RETREAT AT TIMBERRIDGE FILING NO. 2

CONSTRUCTION DRAWINGS

MARCH 2021

Engineering Review
 07/06/2021 8:21:01 PM
 dsdrice
 JeffRice@elpasoco.com
 (719) 520-7877
 EPC Planning & Community Development Department

DESIGNED BY	PRA	SCALE	DATE	02-25-21
DRAWN BY	PRA	(H) 1"= N/A	SHEET	2 OF 22
CHECKED BY		(V) 1"= N/A	JOB NO.	1185.20

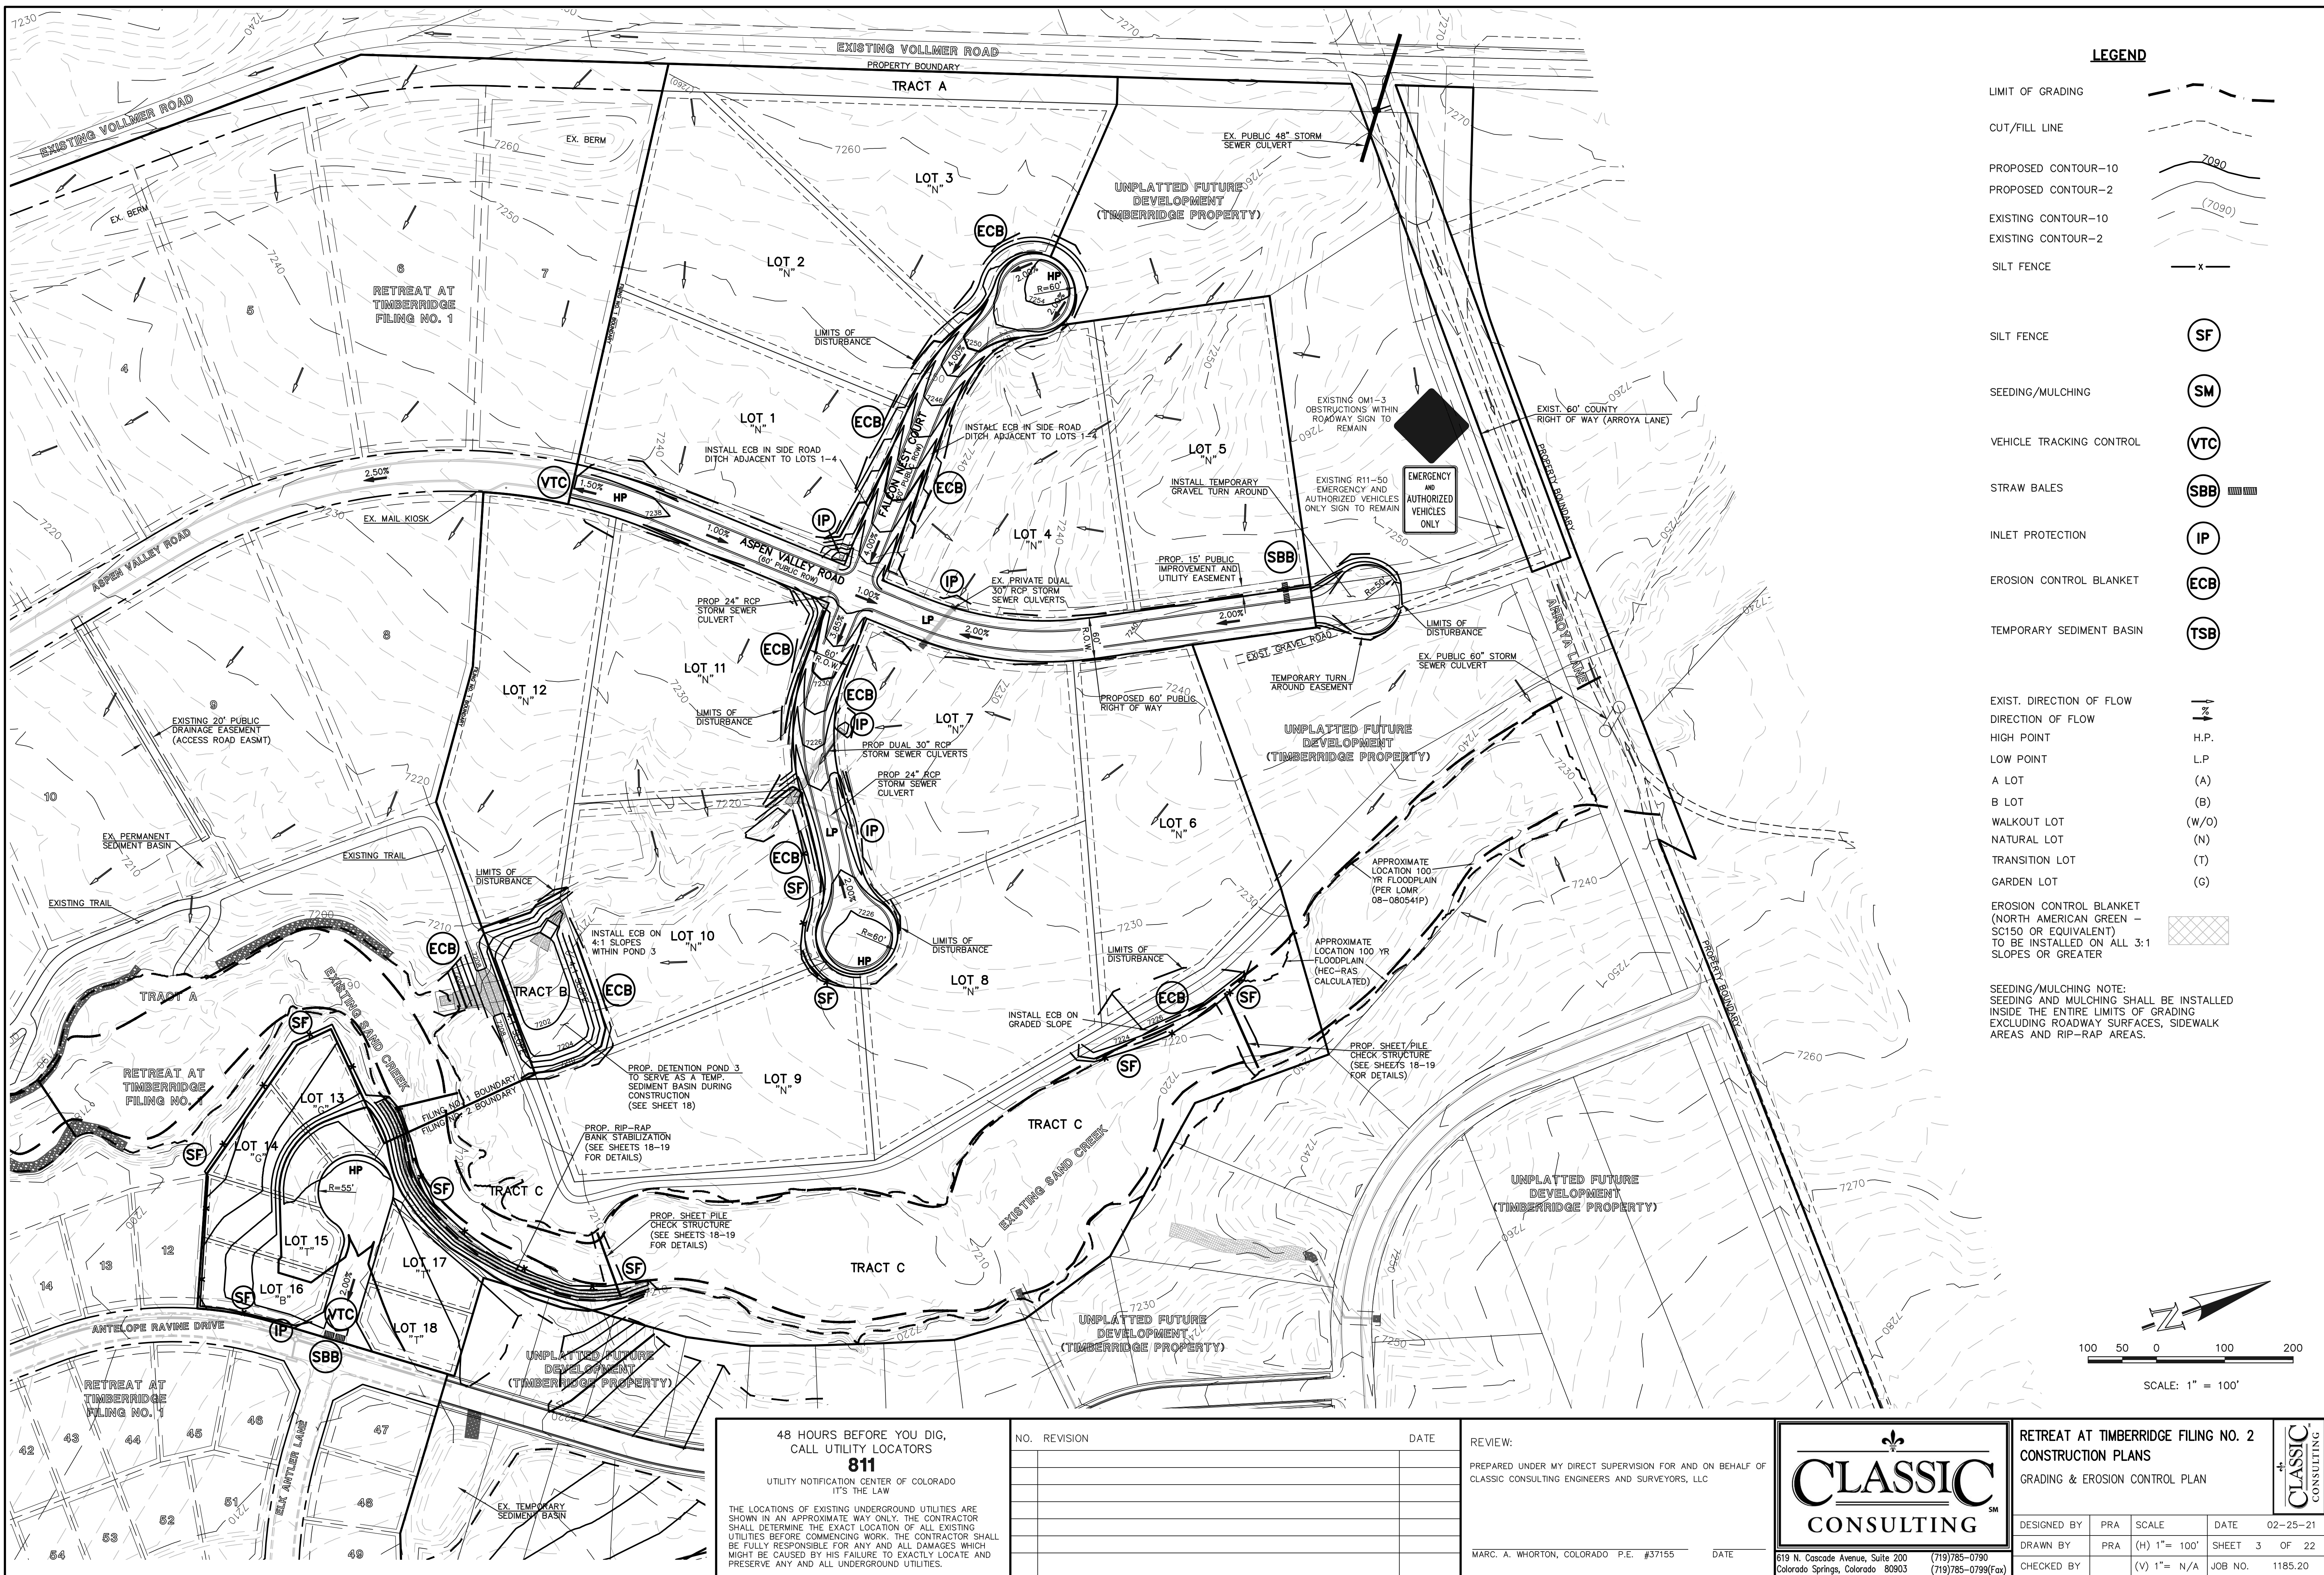
Please include GEC Checklist with next submittal
https://assets-publicworks.elpasoco.com/wp-content/uploads/Stormwater/General_Documents/GEC-Checklist-Template.pdf

replace with text from GEC Checklist Item ii
